Reviewed for Code Compliance
Inspections Division
Approved with Conditions

RE: 89 Pleasant Ave., PI, BP#2017-01190 plan review comments]

S1

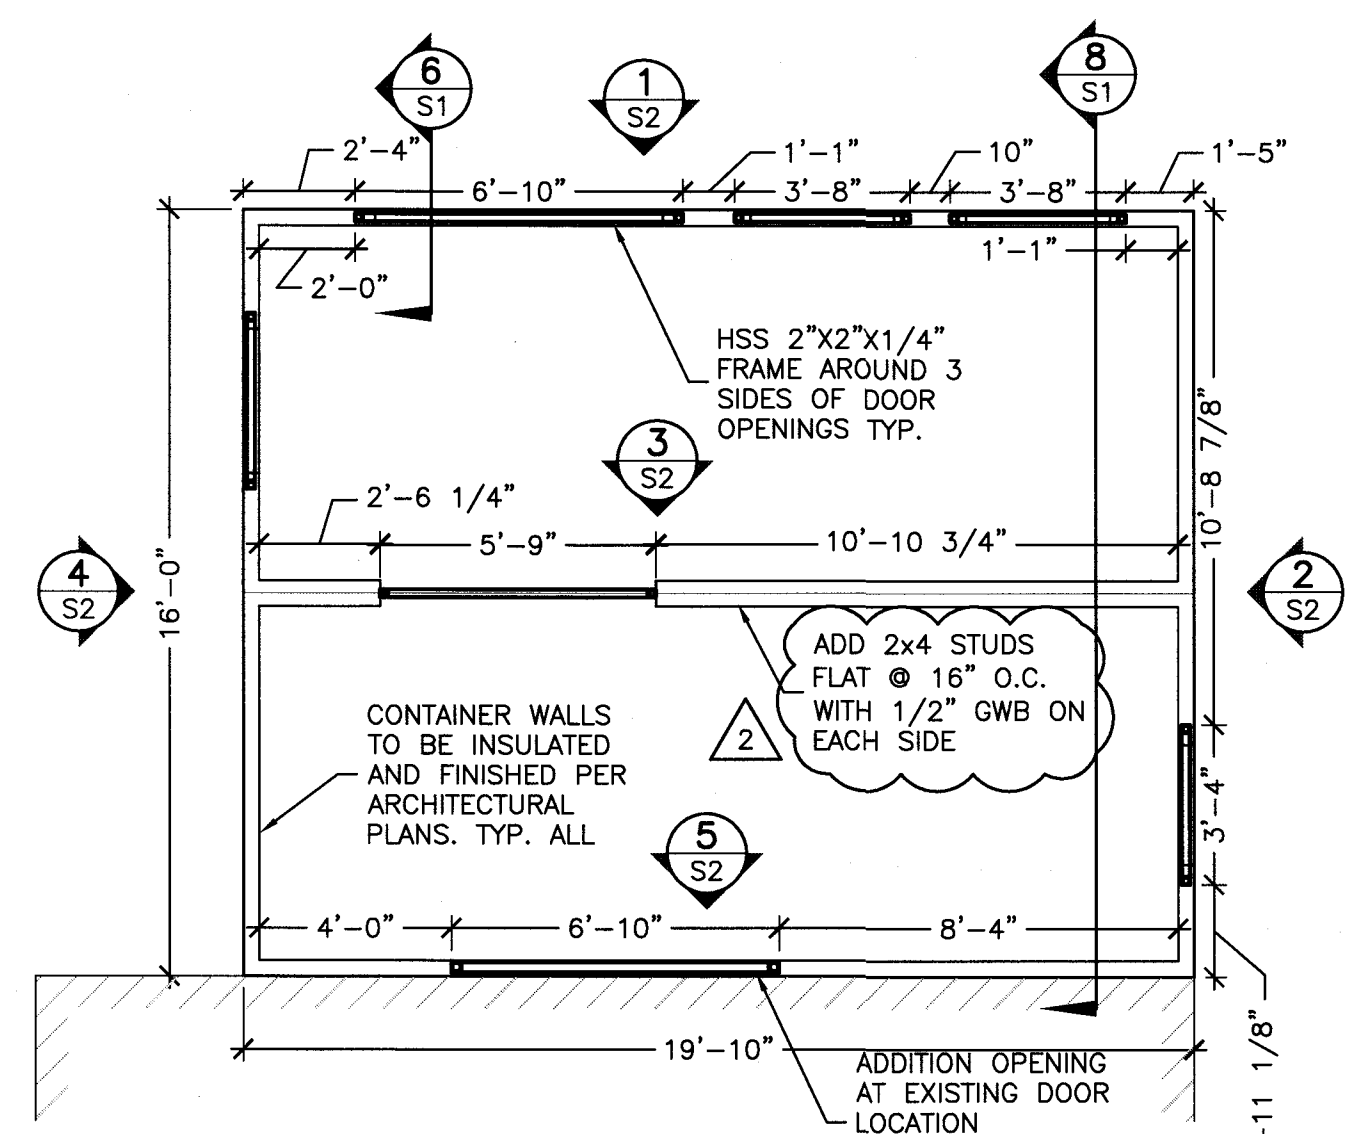
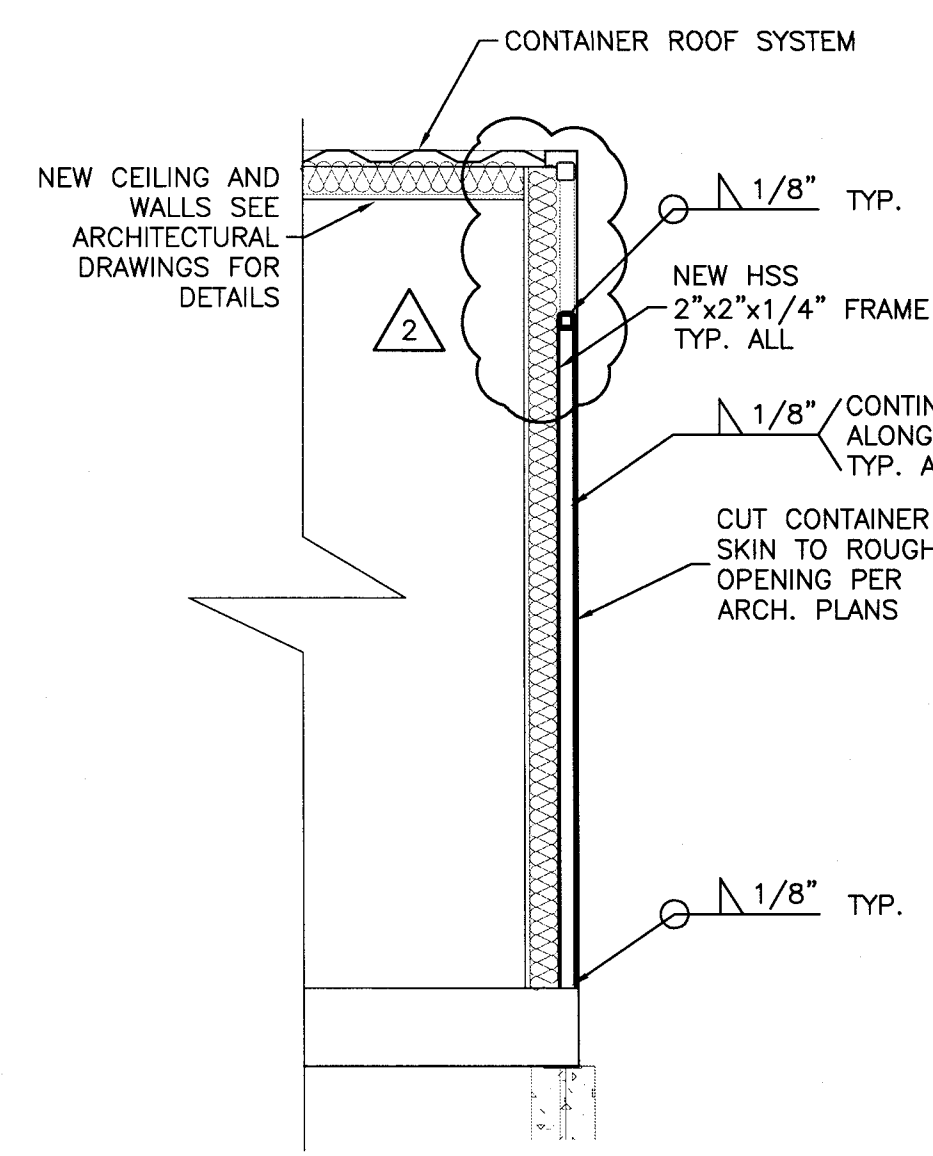
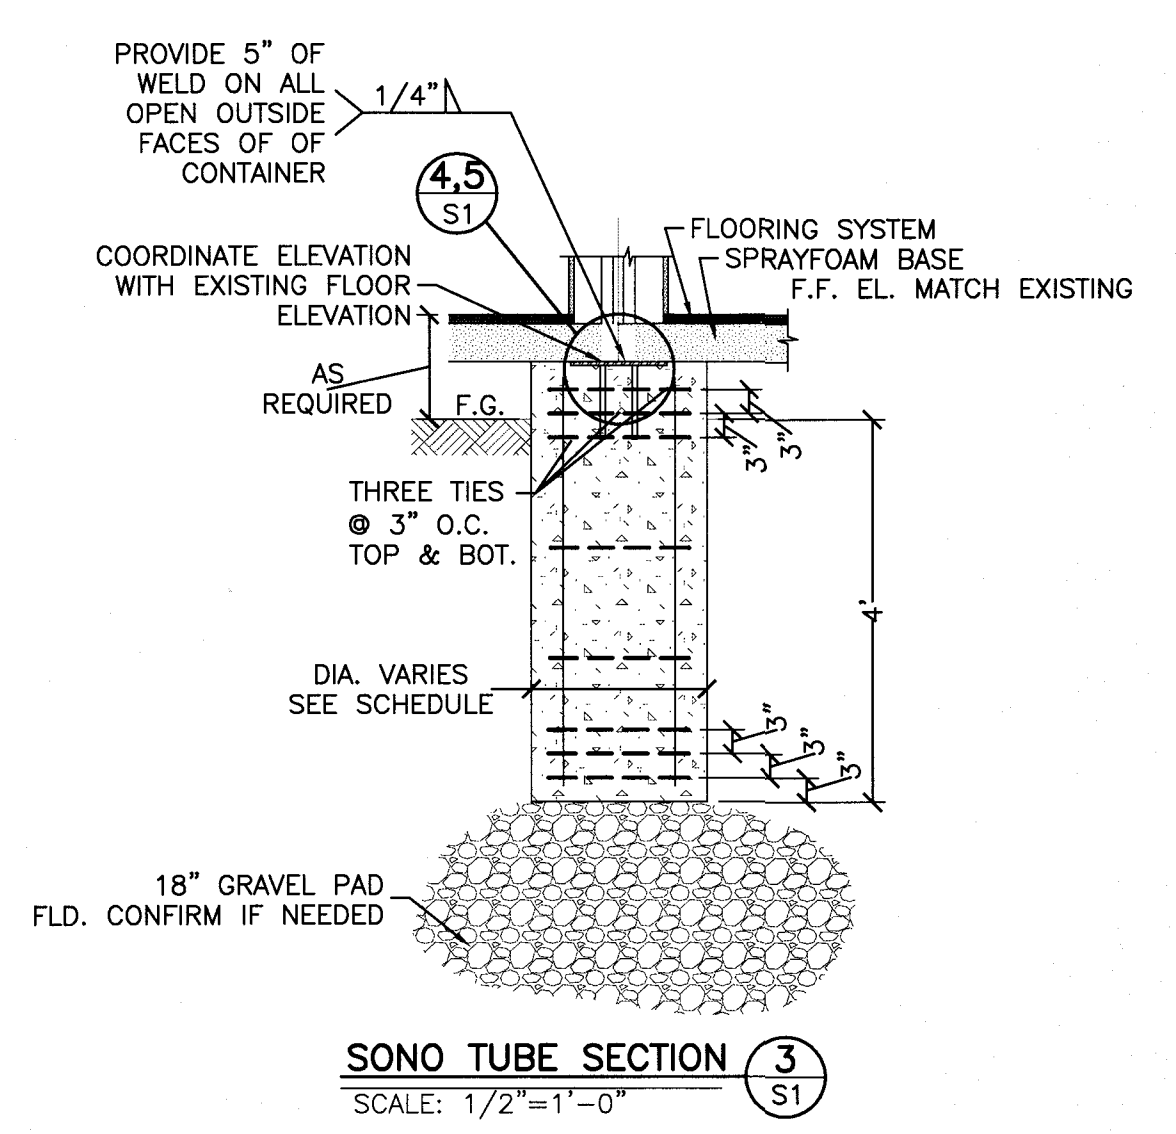
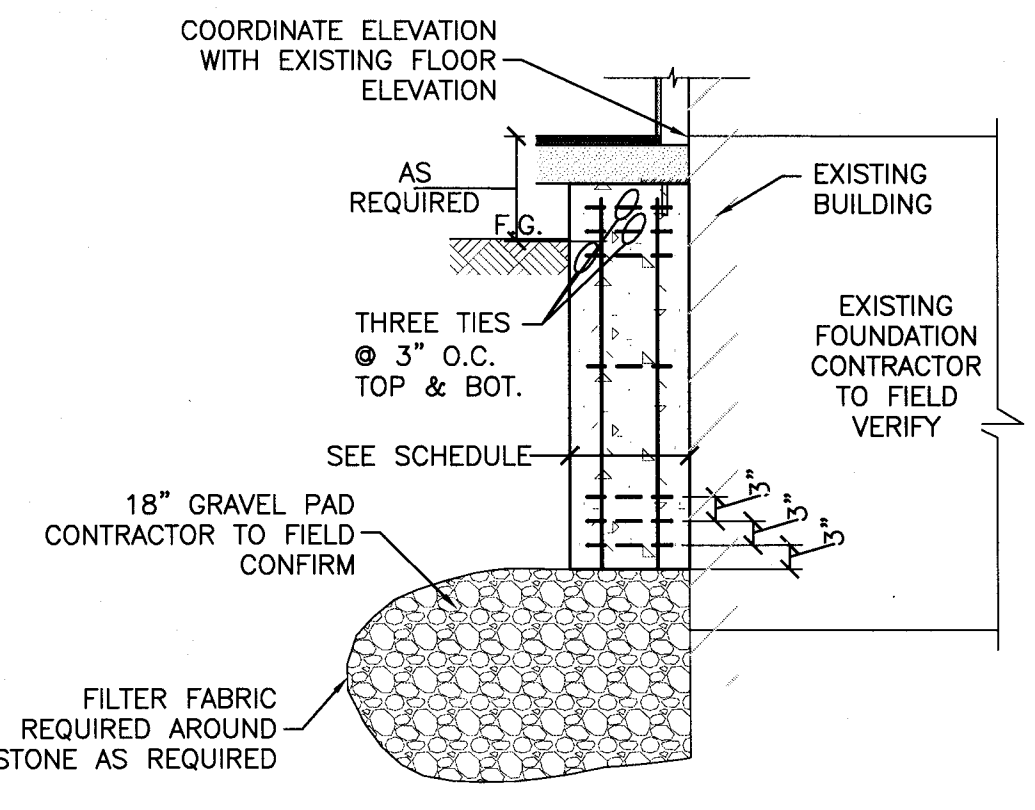
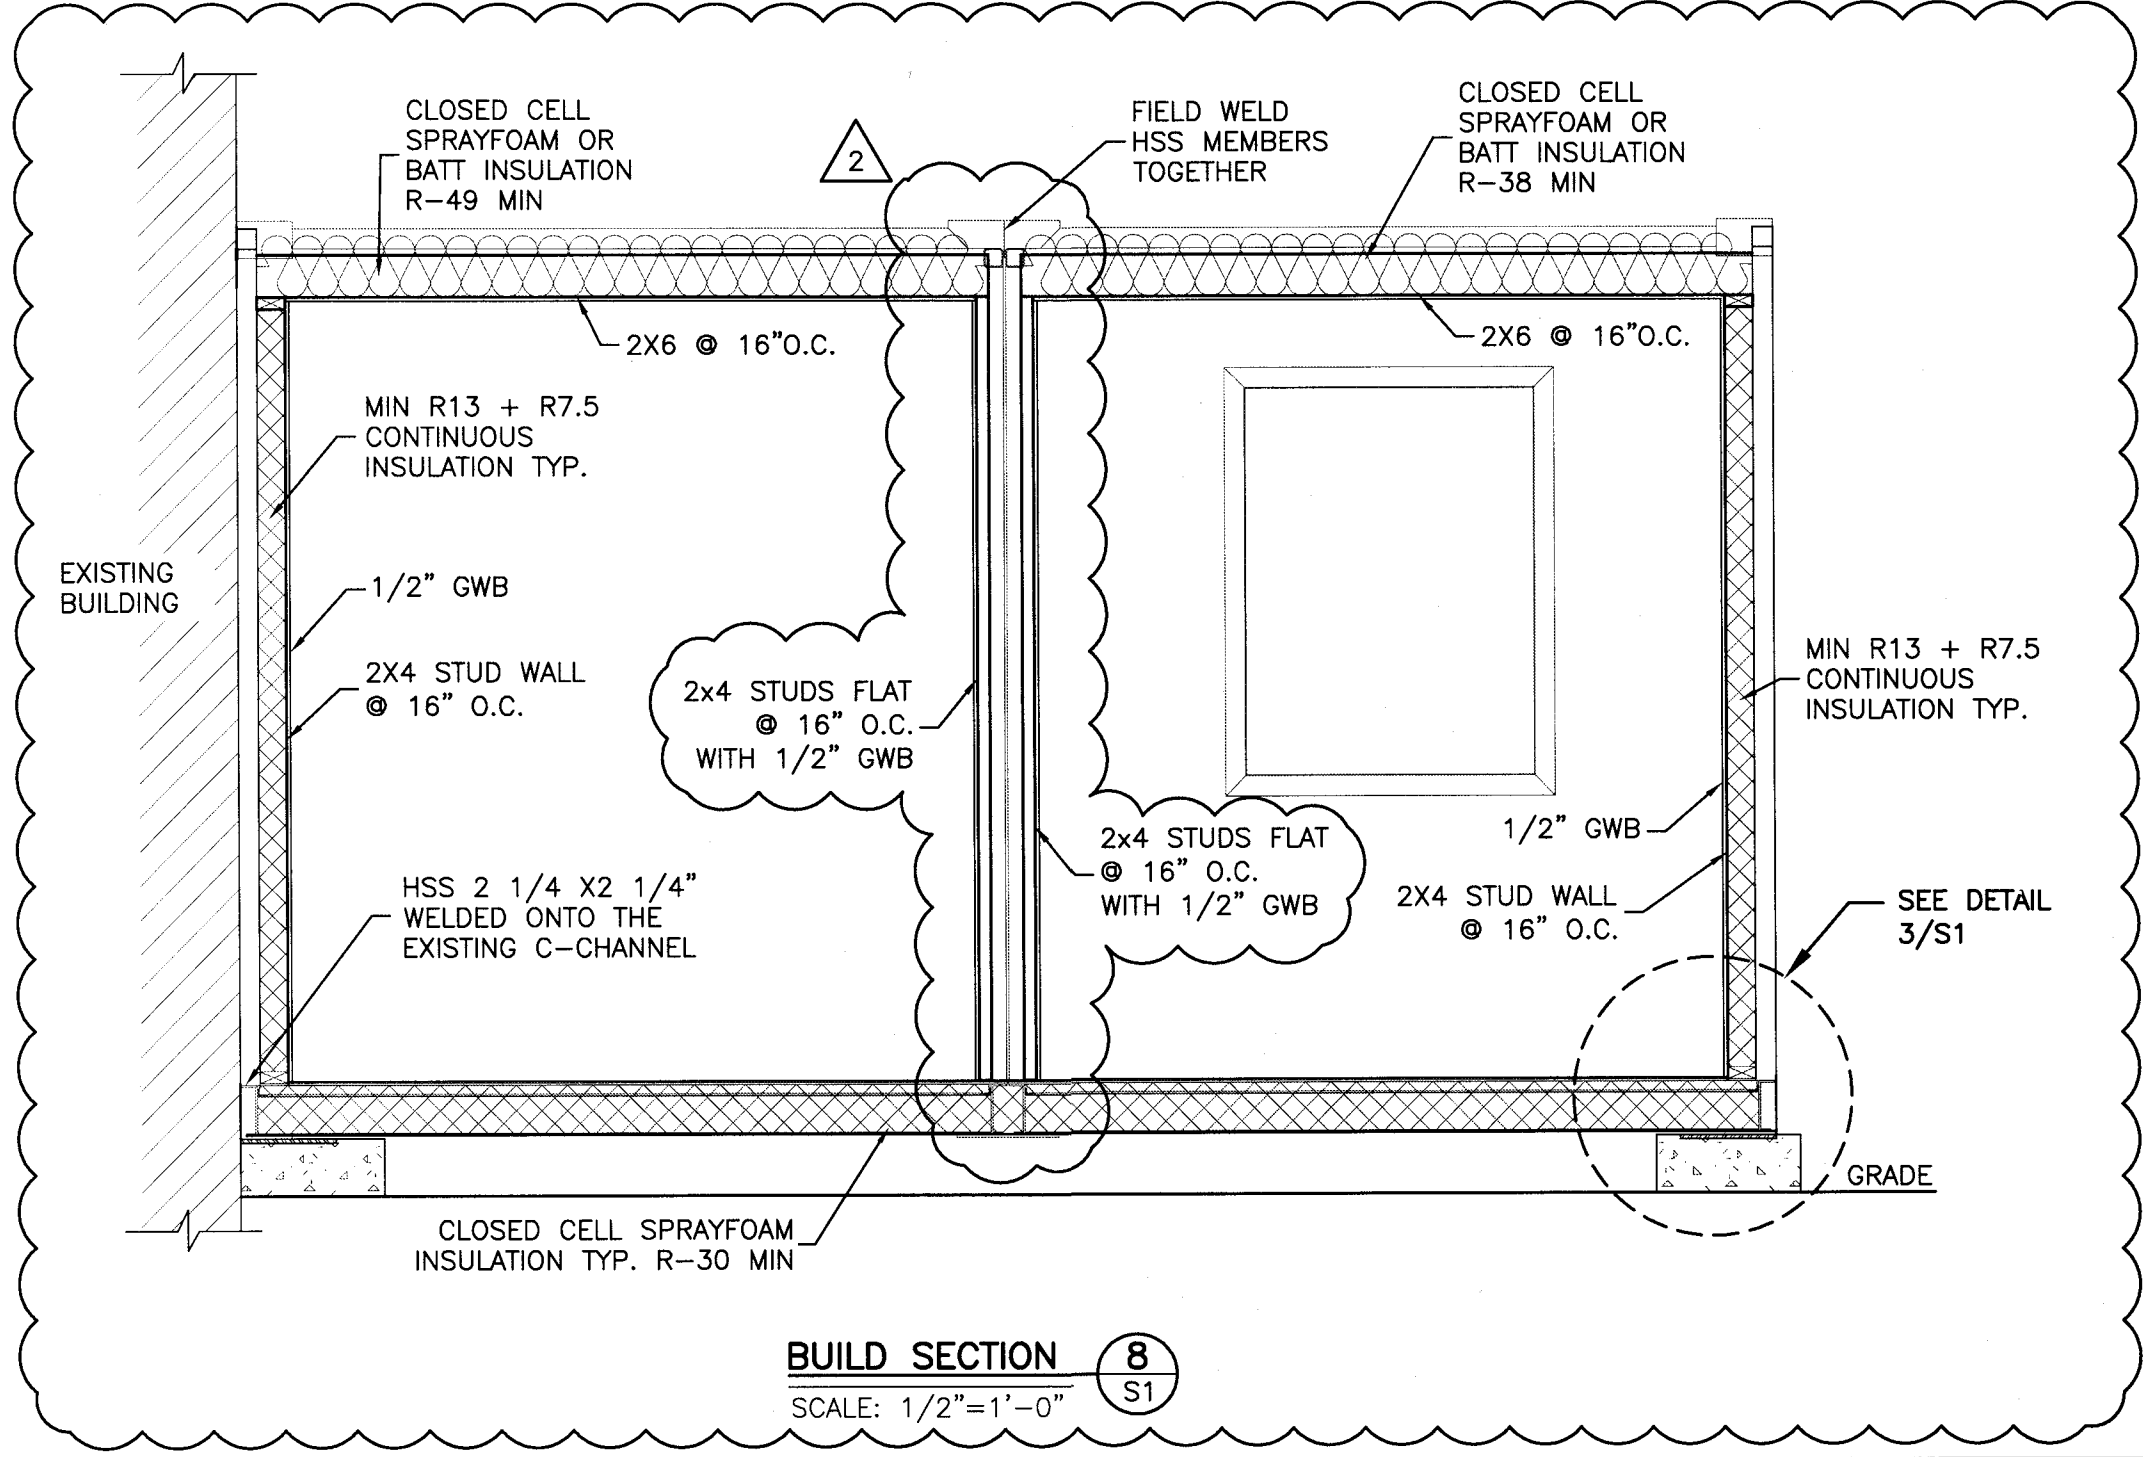
1. Structural plans for the modified shipping container.
These will be furnished by Keith Ewing of Plymouth Engineering (207-257-2071)
2. Structure anchoring specifications and details.
These will be furnished by Keith Ewing of Plymouth Engineering (207-257-2071)

3. Footing & pier dimensions, depth, and reinforcement.
These will be furnished by Keith Ewing of Plymouth Engineering (207-257-2071)
4. Insulation R-factor levels for floor, walls and ceiling.
Dexter Cowperthwaite of SnapSpace Solutions provided the following:
The insulation values will be :
3" in walls (R21)
